From: [REDACTED]
Sent: 09 May 2018 09:36
To: Planning.Responses
Cc: Derek Whittington
Subject: **Warning Active Content** Planning Services Response AL/40/18/PL

TO:	Arun District Council FAO: Mr S Davis
FROM:	Highways, WSCC
DATE:	09/05/2018
LOCATION:	Land adjacent to, 14 St Johns Close, Westergate, Aldingbourne, PO20 3TH
SUBJECT:	AL/40/18/PL 2 No. semi detached bungalows with associated parking & landscape.
DATE OF SITE VISIT:	
RECOMMENDATION:	☒ Advice ☐ Objection ☐ Modification ☐ No Objection ☐ More Information ☐ Refusal
S106 CONTRIBUTION TOTAL:	£N/A See below for breakdown.

Plans and elevations of cycle stores

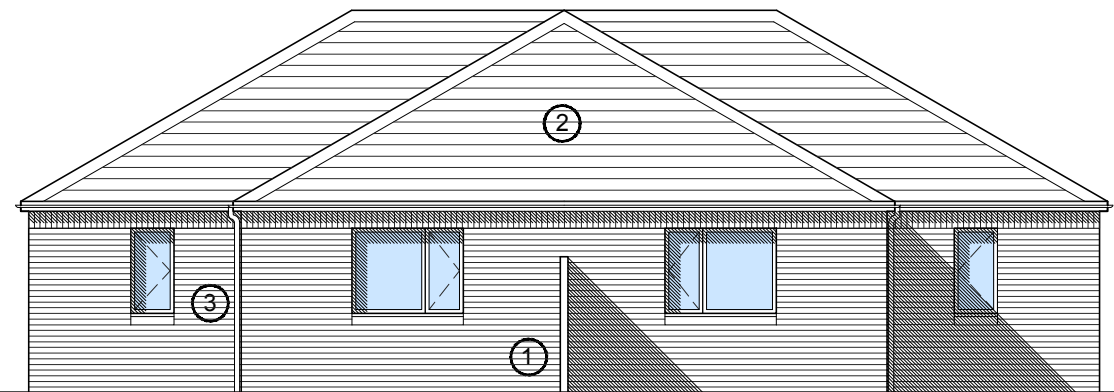
The site is located approximately a 15 minute bicycle ride from Barnham train station. To encourage the use of sustainable transport methods, the LHA would advise that secure, covered bicycle storage is provided.

No part of the development shall be first occupied until covered and secure cycle parking spaces have been provided in accordance with plans and details submitted to and approved by the Local Planning Authority.

location plan &
proposed site plan

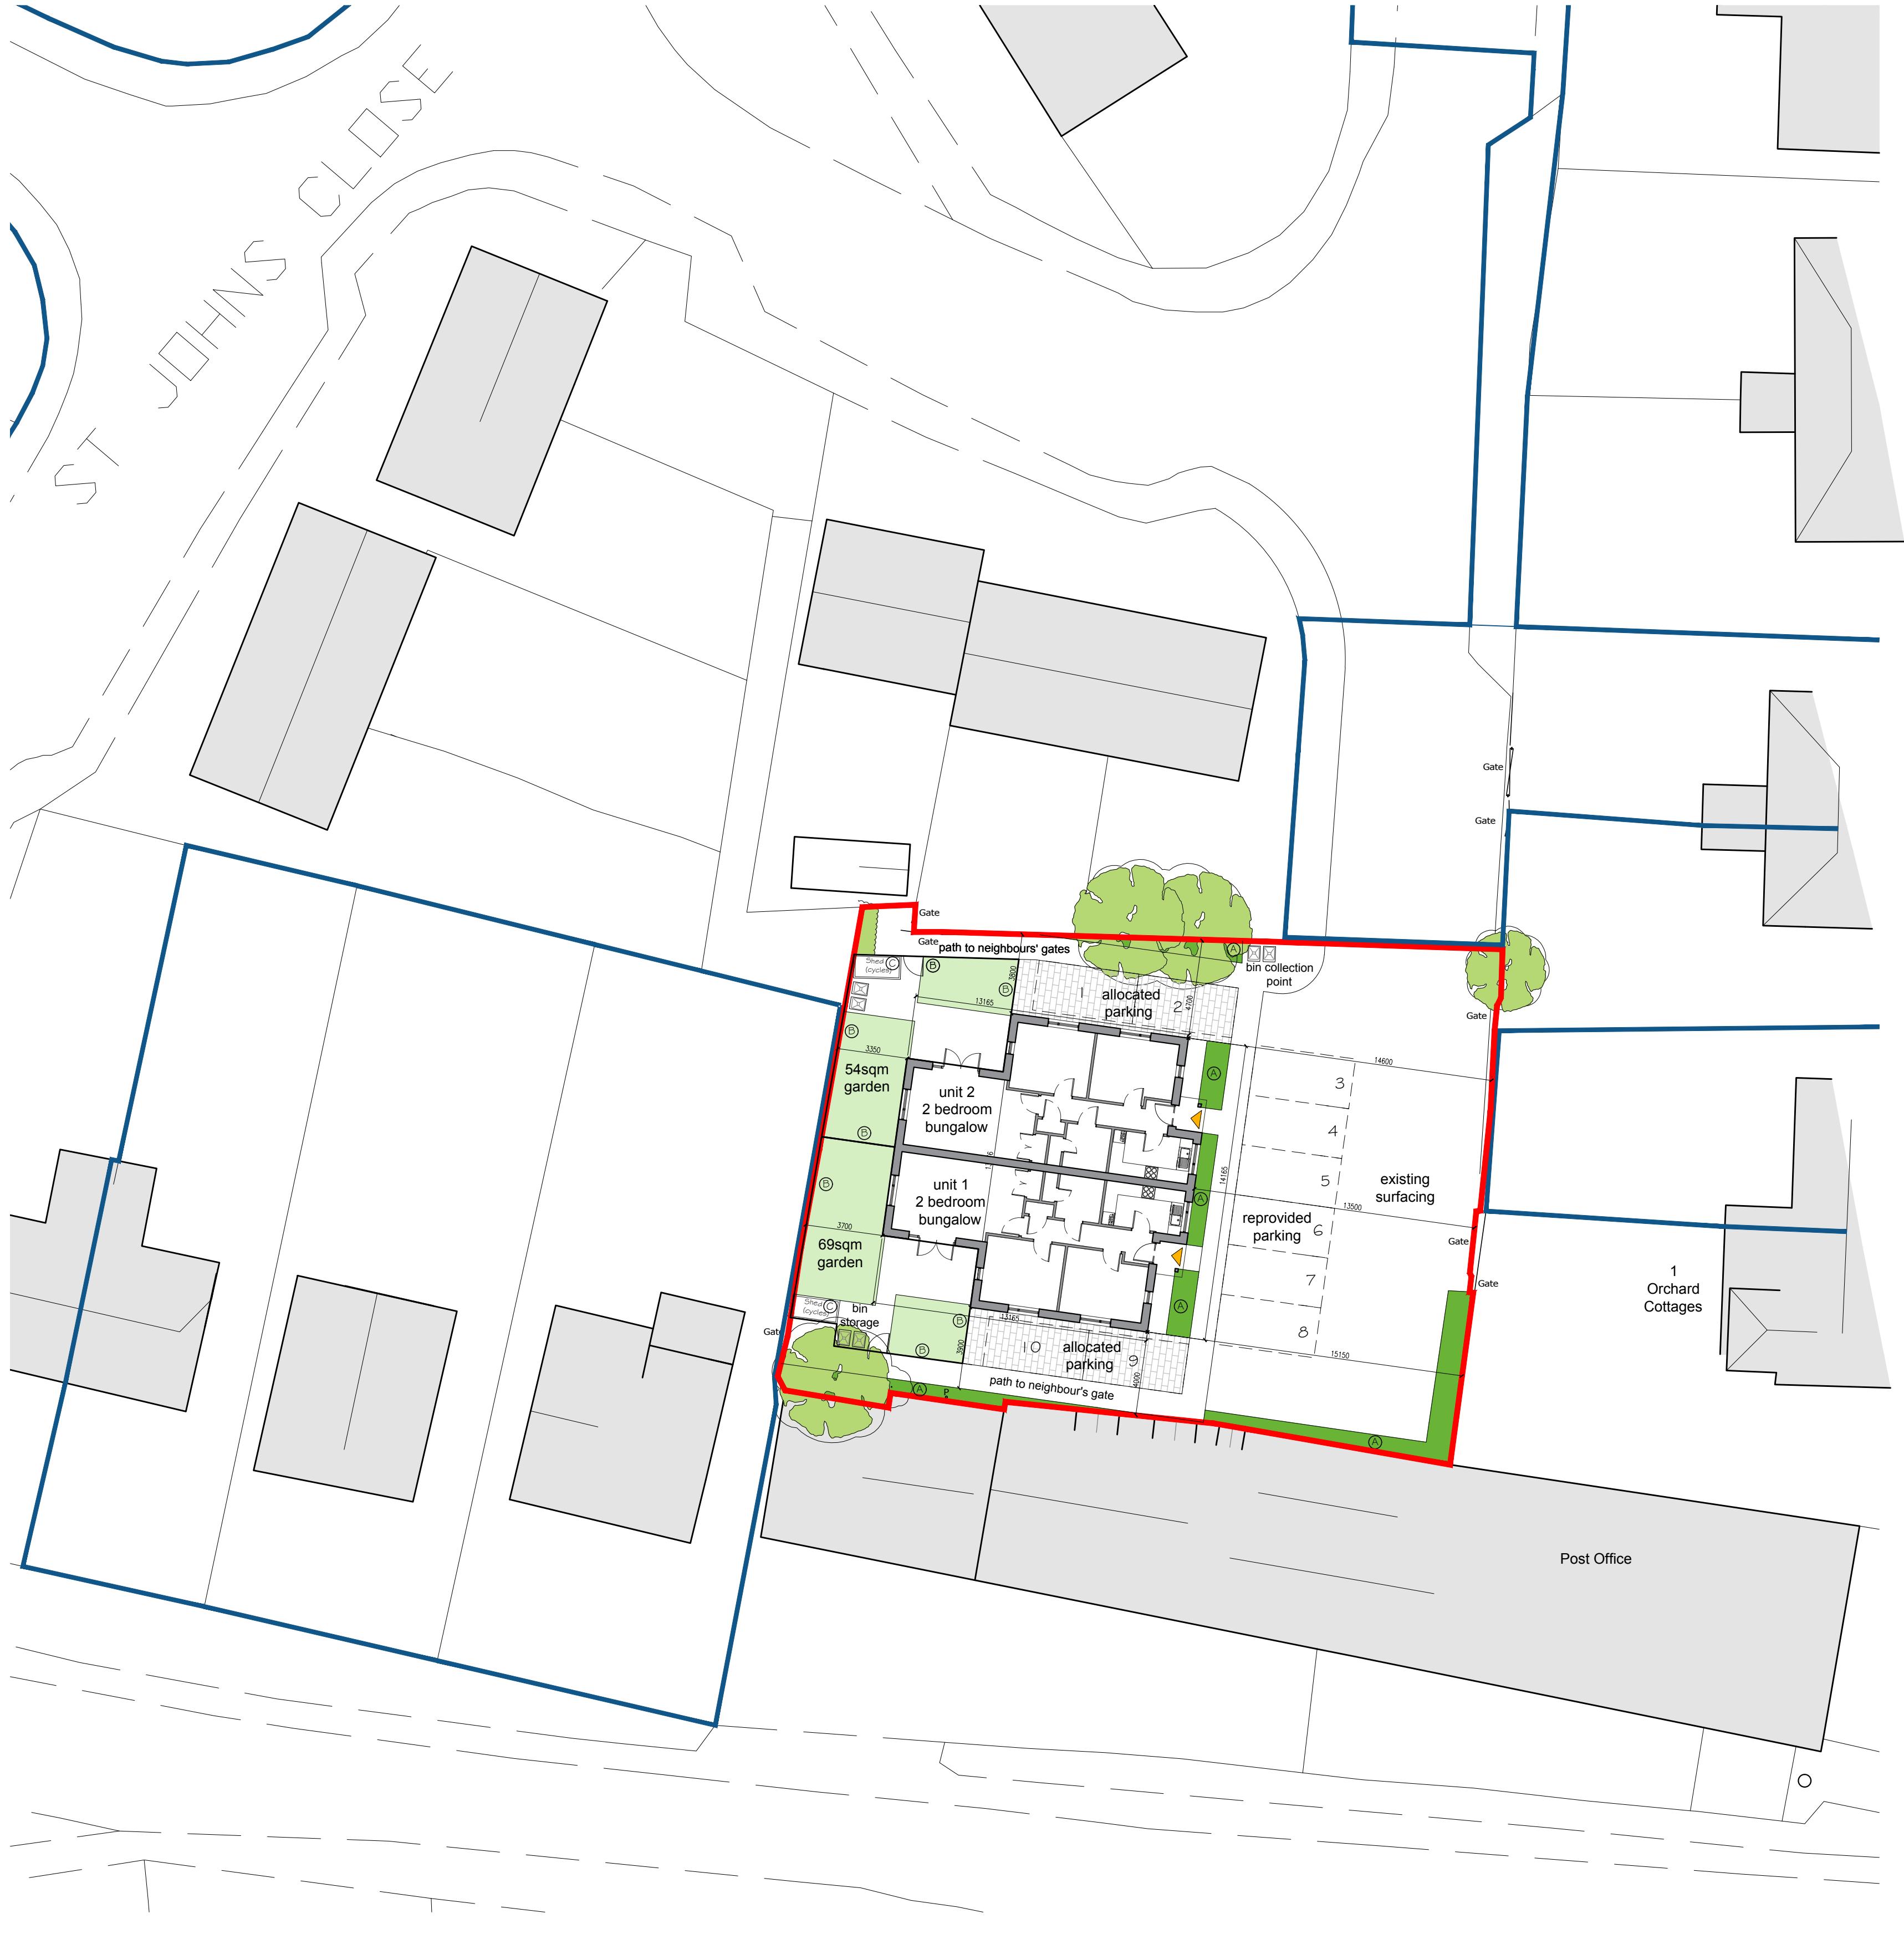
The WSCC car parking calculator would envision a total of 4 parking spaces for both dwellings. By taking approximate measurements from the plans provided it appear that the parking spaces meet the minimum dimensions stated in Manual for Streets (MfS) of 2.4m x 4.8m. Plans detail 2 parking spaces will be provided per dwelling which meets the predicted, and an additional 6 unallocated parking spaces will be re-instated for the shared use of neighbouring dwellings.

From an inspection of the plans the LHA are satisfied that the site can facilitate turning for cars and that access for Fire and Refuse Vehicles is achievable.

No part of the development shall be first occupied until the vehicle parking and turning spaces have been constructed in accordance with the approved plan. These spaces shall thereafter be retained for their designated use.
